Planning Application No: 2026/62/91926/E

Address: 158 Hawthorne Way Shelley

Description: Change of use of garage to treatment room for hairdressing including installation of bi-fold doors to existing opening

Drawing Title: LOCATION PLAN

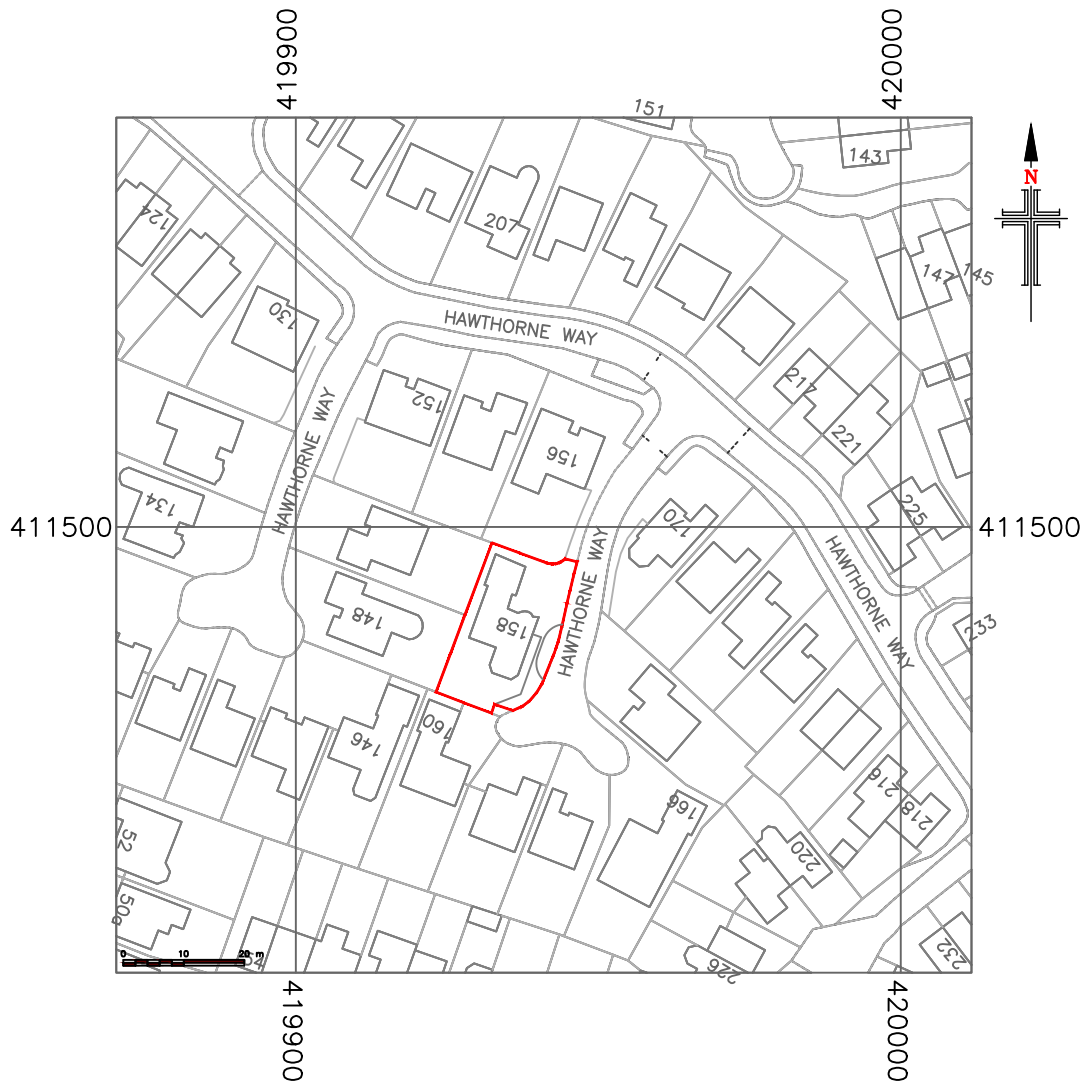
The location plan has now removed the visitors parking space from the application redline, the drive has been altered to show three parking spaces side by side and that the bi-folds now open inwards.

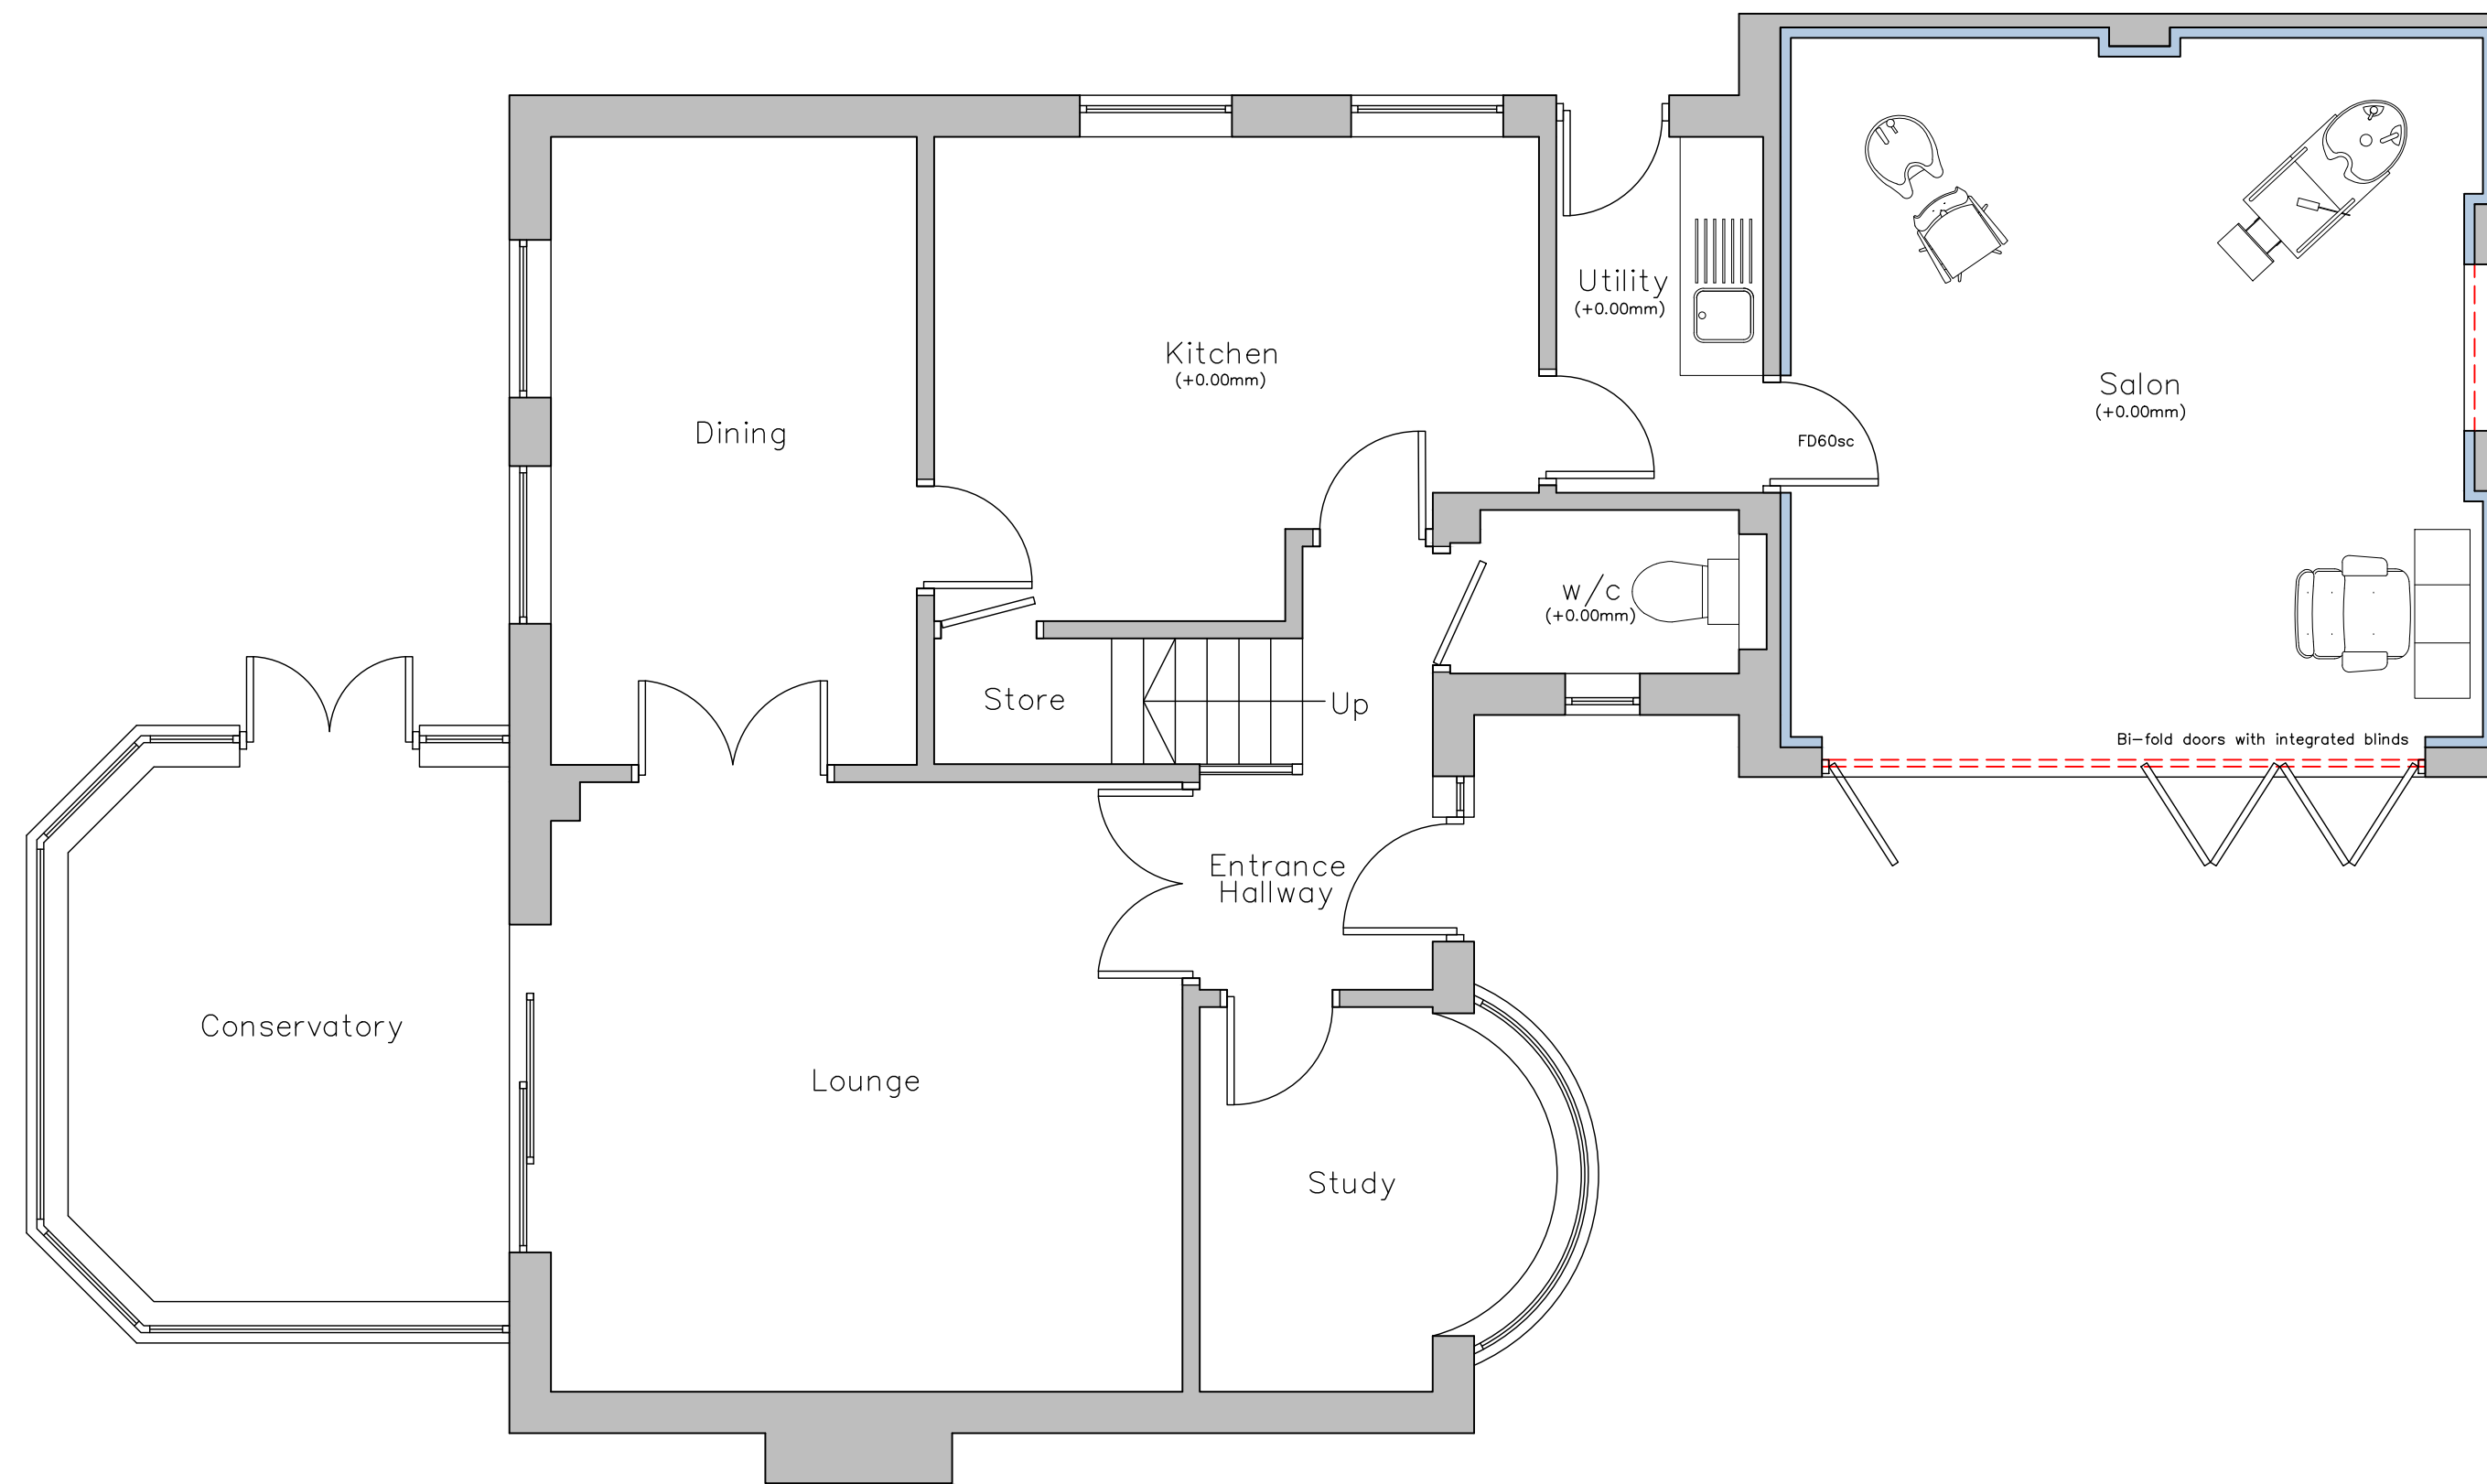
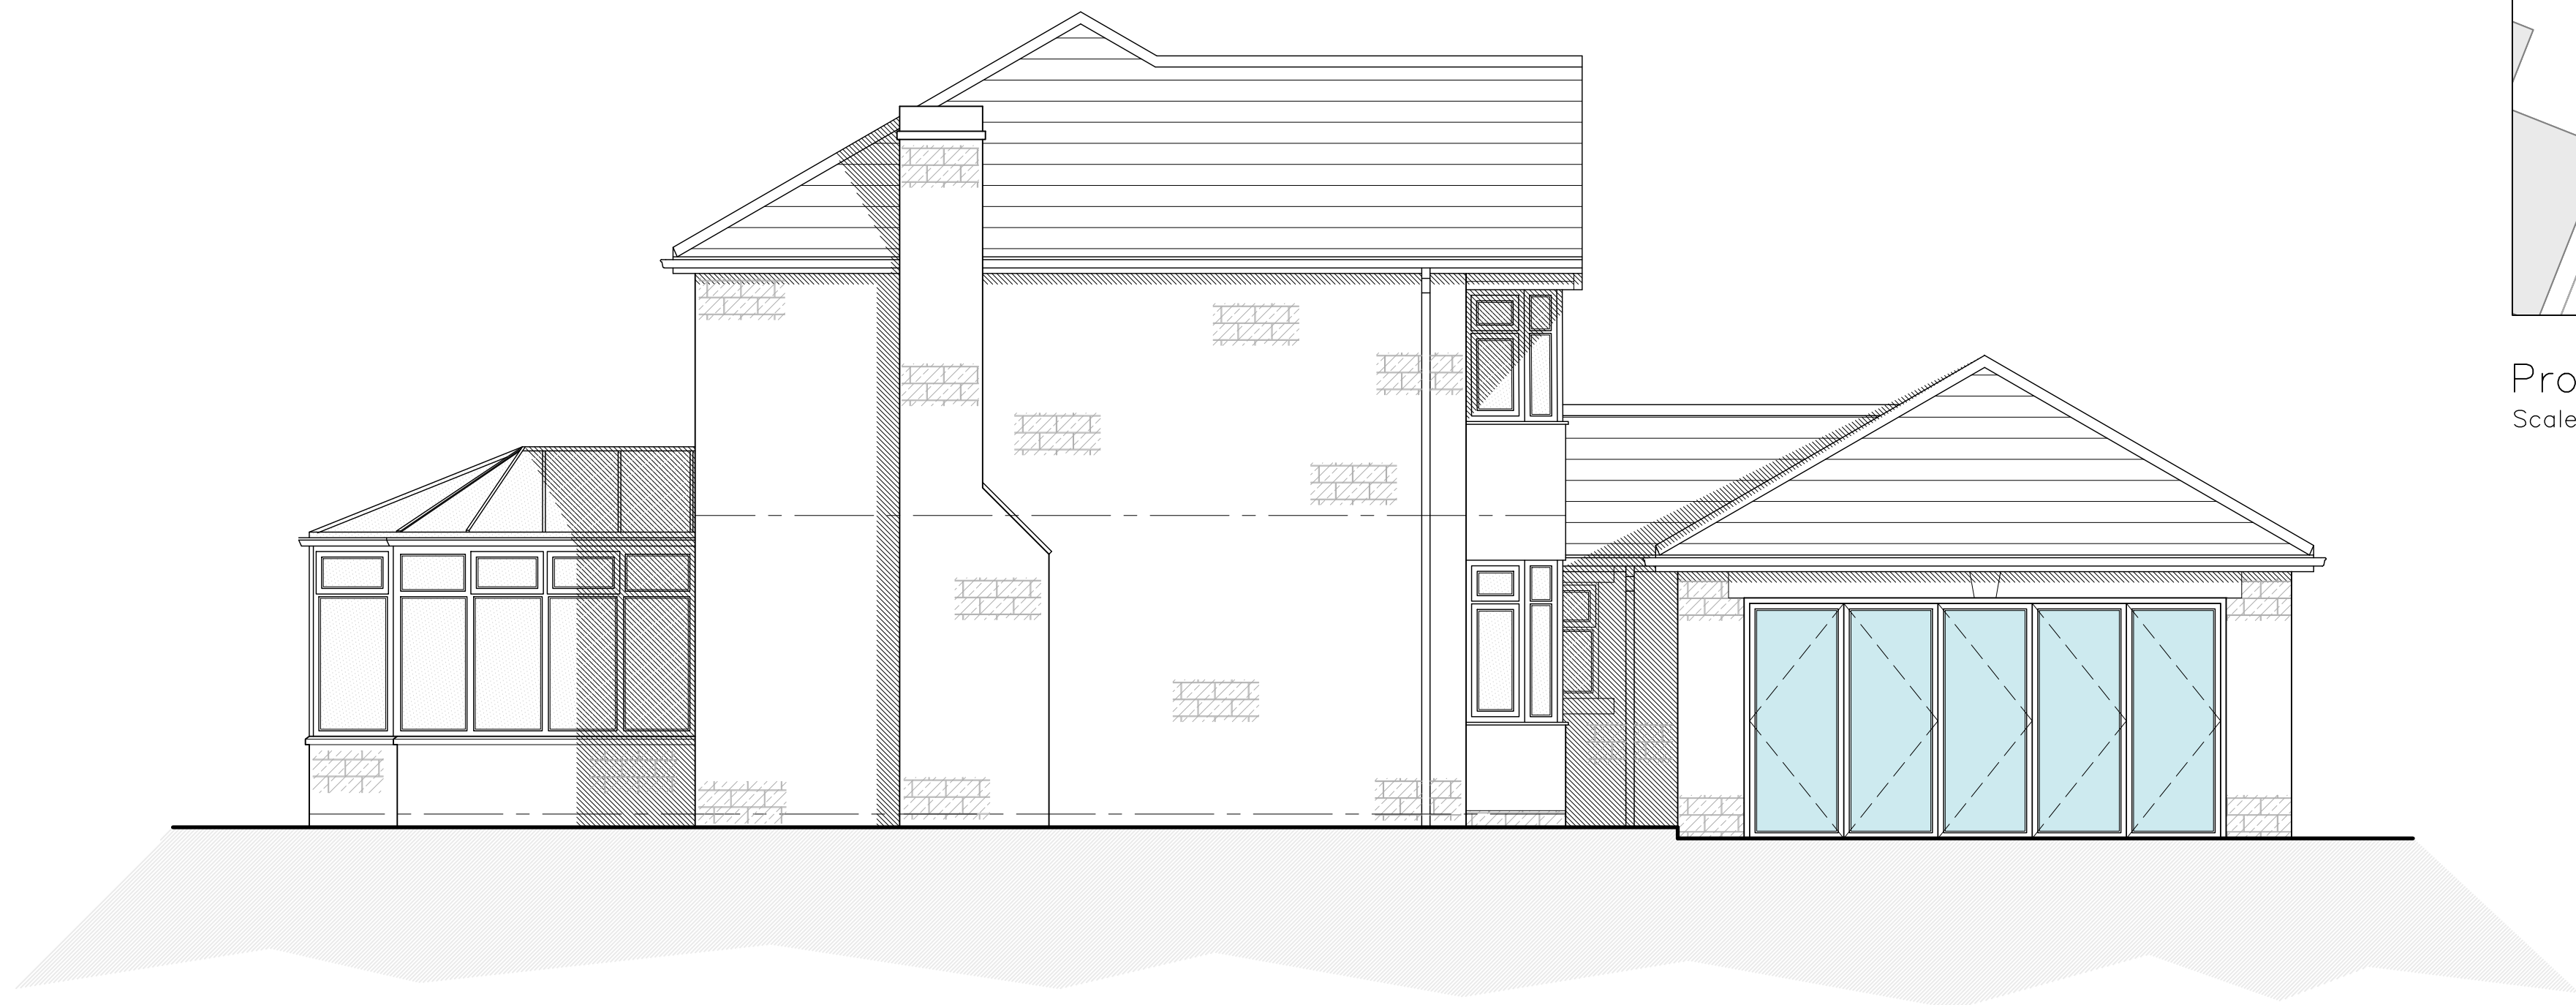
The amended 383-26-PL02 Rev B submitted 14.9.26 shows three parking spaces which can now be accessed independently of one another, a preferred requirement of DC highways officers in my experience. The three spaces are the minimum required for any garage conversion due to the loss of 2 spaces from within the garage, regardless of its use.

However, the application as amended now doesn't provide the 4th off-street parking for customers, due to the proposed business use. Given our previous comments which clearly show that 75% of the time there are always 2 customers at the property at any one time surely the application should provide for two additional spaces. As this cannot be provided the application should be refused on highways grounds.

In order for the three spaces to be provided as shown, the existing drive will need to be extended again. The drawings don't indicate how this will be done nor has it been added to the description. Unless drainage is to be provided planning permission would also be required for this, however given the sloping nature of the drive appropriate drainage would be difficult to achieve.

The amended plans showing the bi-fold inwards does reduce the obstruction on the drive for parking, but doesn't overcome our previous concerns with regards: -
